**Addendum No. 1**

RE: Contract # C204578  
WBS # 2021CPT.08.02.10191  
STATE FUNDED  
**Chatham County**  
1 SECTION OF US-64.

**December 15, 2020 Letting**

The following revisions have been made to the Sketch Maps:

MAPS #1 & #2

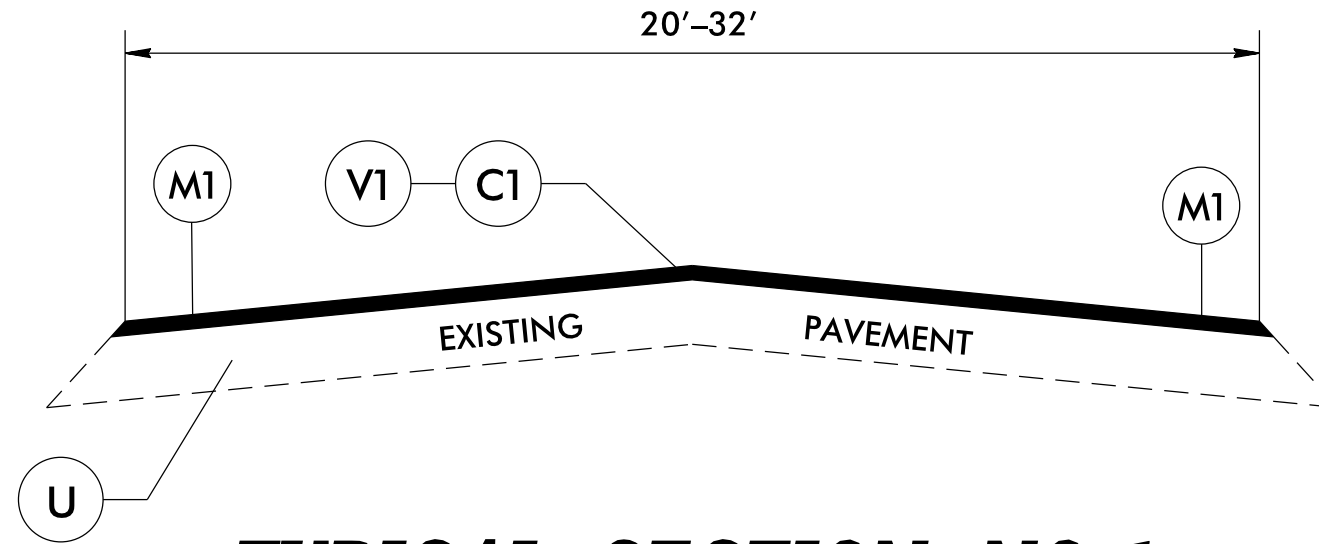
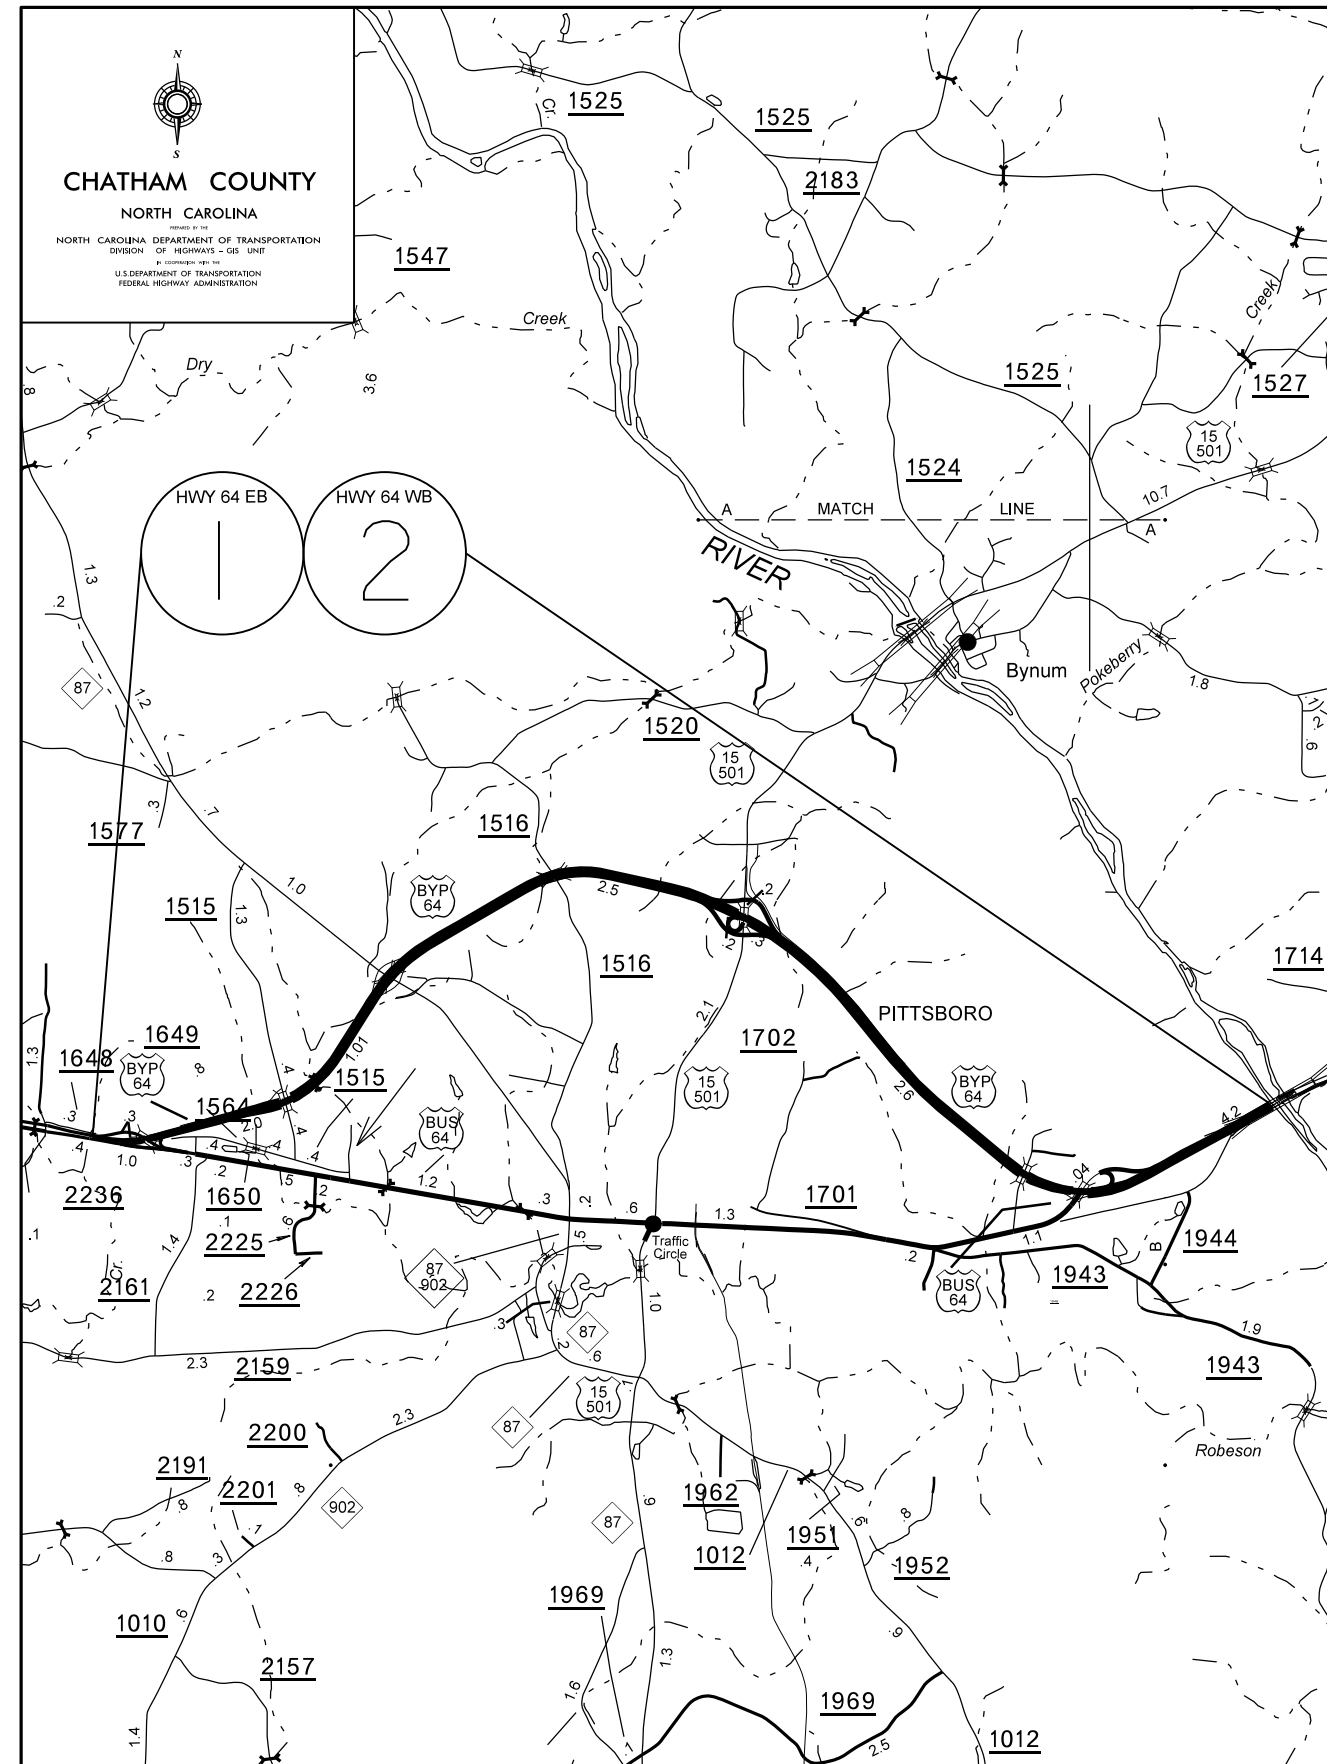
Sheet No.	Revision
2	Note added to clarify project limits
